P/127/25/DOC pre submission comments

I have reviewed the details within the EMMP.

I cannot recommend discharge of Condition 15 at the present time.

Figure 19. A schematic of how the Cambridge full face Swift brick leads into a cavity created by the prior installation of the Swift maxi nesting box.

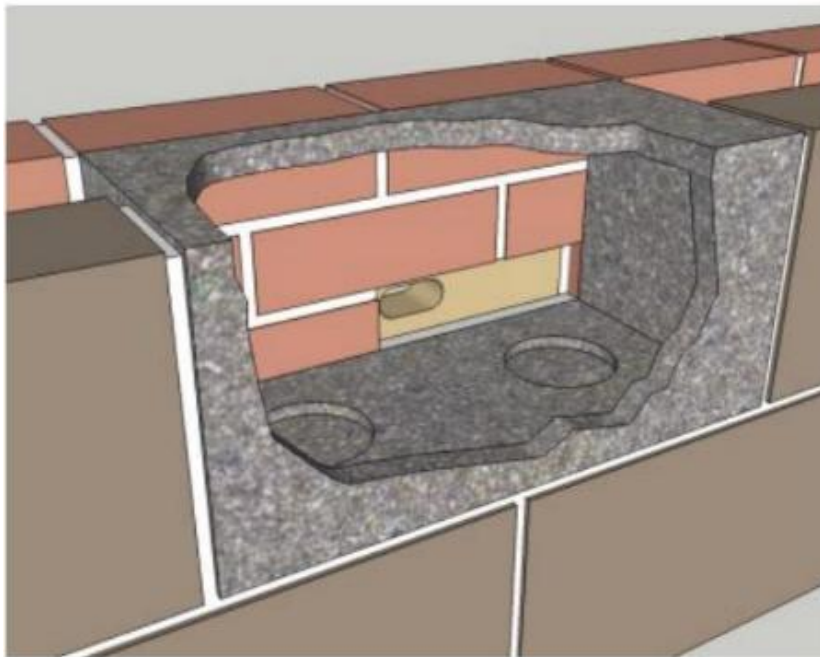
The EMMP states 'each of the new dwellings on site will have at least 1 No swift brick incorporated into the building'. The Cambridge Swift brick is fine. The CJ Maxi box referenced is not integral and should not be used.
